**KIRKLEES METROPOLITAN COUNCIL
INVESTMENT & REGENERATION SERVICE**

Reference No:	2023/62/91490/W
Site Address:	11, Chancery Lane, Huddersfield, HD1 2DT
Description:	Conversion of ground floor and alterations to basement to form two flats (Listed Building within a Conservation Area)
Recommending Officer:	Lucy Taylor

DECISION – REFUSED

Officer Report.

CHANCERY LANE - CONVERSION GROUND FLOOR LAYOUT

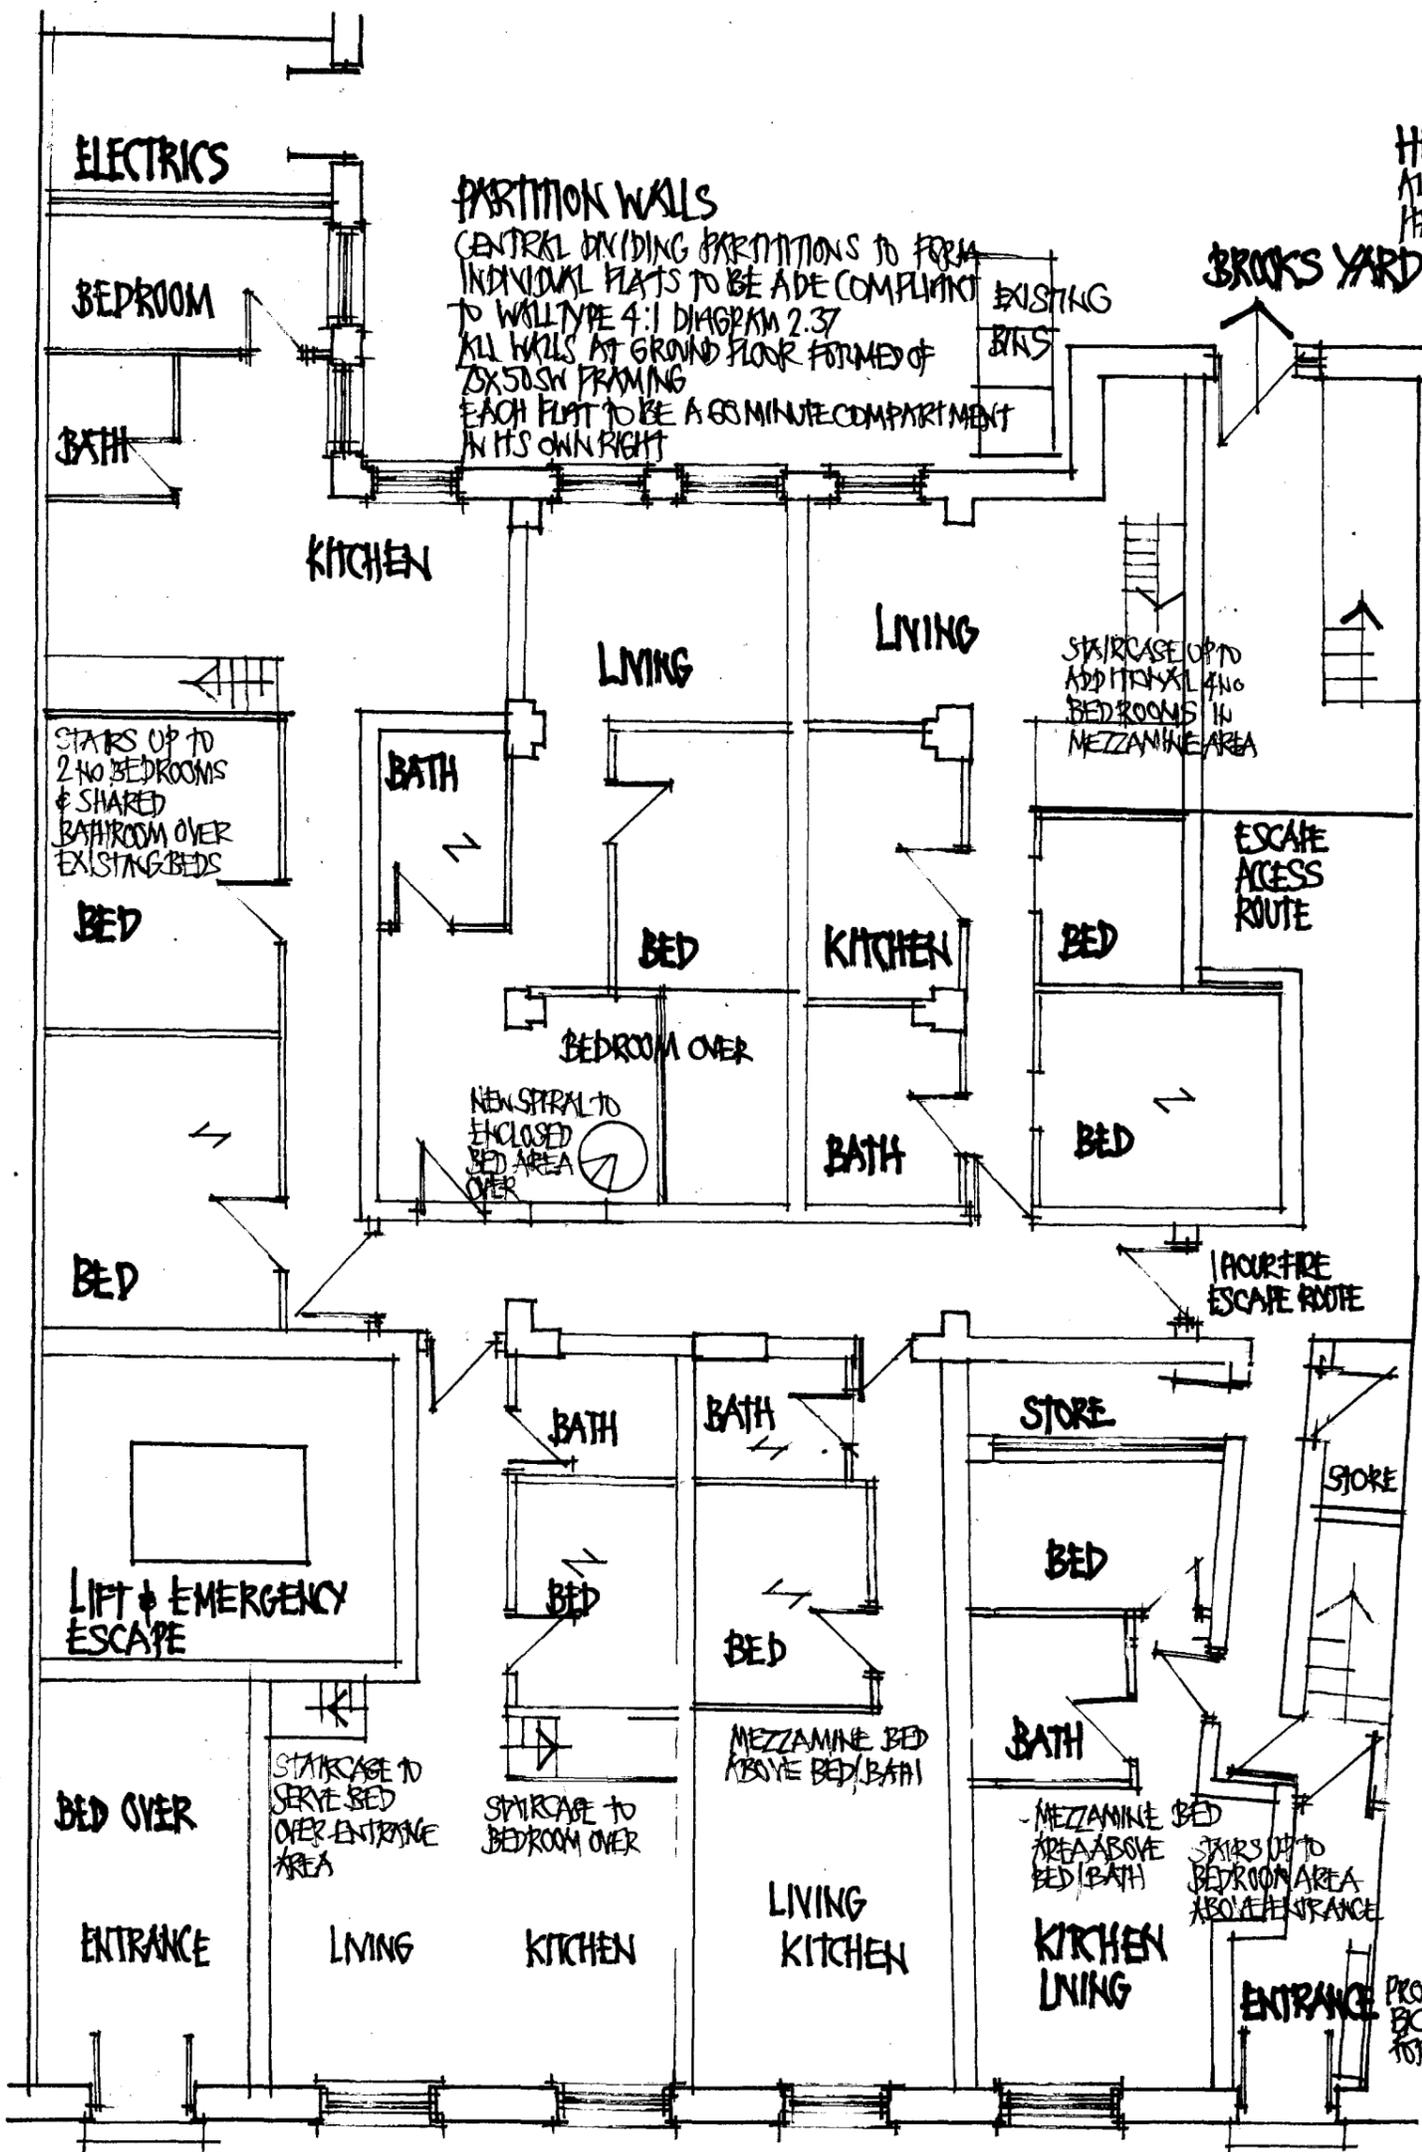
Whilst it has been acknowledged that there would be windows to serve both flats, give the low-level position of the windows and their close relationship with surrounding built form, it is not considered that these windows would allow for adequate natural light or outlook.

The windows to the front elevation of the flats would face directly onto the narrow highway of Chancery Lane, with no separation between the highway and the principal elevation of the host building. In addition, a three-storey building is located directly adjacent to the principal elevation of 11 Chancery Lane, separated by approximately 9 metres, with multi-storey buildings surrounding the site within the wider streetscene.

With regard to the rear window, the site adjoins a two-storey building to the south and another two-storey building is located directly adjacent to the rear elevation, separated by only approximately 5.5 metres. Therefore, it is considered that the lack of natural light would result in substantial levels of amenity for future occupiers.

‘Flat 1’ would have the same internal area as the flat proposed under previous application 2022/93175. In turn, it is considered that the proposed flat would fail to comply with the Nationally Described Space Standards.

It is noted that no specific storage space has been demonstrated on the submitted floor plans for either of the proposed flats.

No private outdoor amenity space would be provided for either of the proposed flats. The principal elevation of the building is set directly onto the highway of Chancery Lane and the rear elevation backs onto land utilised as a car park. The Town Centre location is noted, but the lack of such a private amenity space is considered to add to the poor standard of amenity of the proposed residential units.

The submitted plans show that bins would be located to the front of the building. However, via email communication, the planning agent suggested that bins would be located within the existing bin store in Brooks Yard and that tenants could use the existing bin store that serves the adjacent flats. Upon any grant of approval, a pre-commencement condition would need to be imposed to clarify waste storage arrangements. Although this information and clarification would usually be collected prior to determination, it would be considered unreasonable to do so in the instance of this application, with this application failing to overcome reason one of refusal under 2022/93175.

Officers would want bin storage to be located away from Chancery Lane, as putting the bins to the principal elevation would result in an obstruction on the public highway to the detriment of highway safety.

PROPOSED G. FLOOR

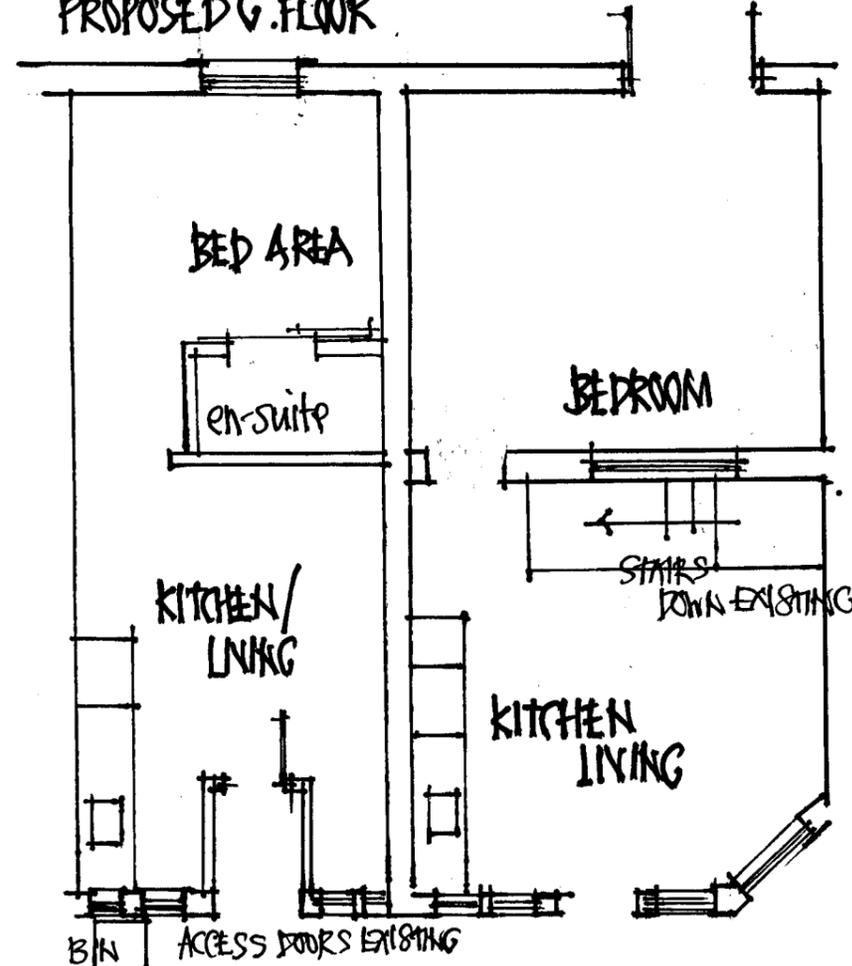
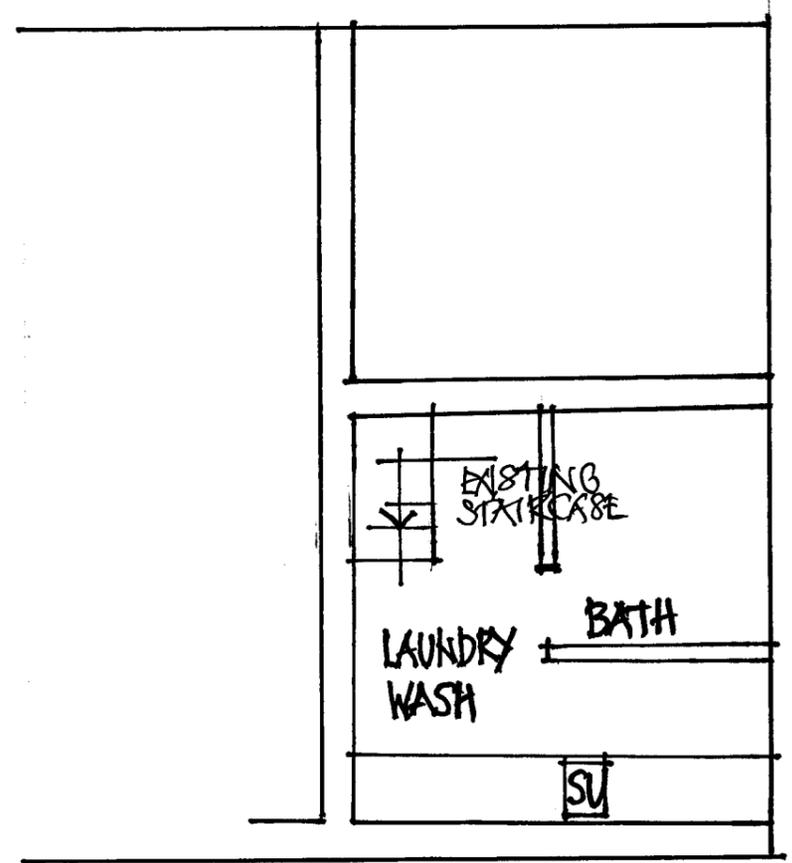
The submitted plans show that the flat would be accessed via a front access door off Chancery Lane and a new opening in conjunction with the adjoining building of 13-17 Chancery Lane. Via email communication, the planning agent suggested that the access would be via the reopening of a former door from the bed area to the adjacent store in 13-17 Chancery Lane. In the event

The submitted plans show that bins would be located to the front of the building. However, via email communication, the planning agent suggested that bins would be located within the existing bin store in Brooks Yard and that tenants could use the existing bin store that serves the adjacent flats. In the event of any grant of approval, a pre-commencement condition would need to be imposed to clarify waste storage arrangements.

‘Flat 2’ would appropriately comply with Nationally Described Space Standards for one-bedroom flat over two stories with two occupiers.
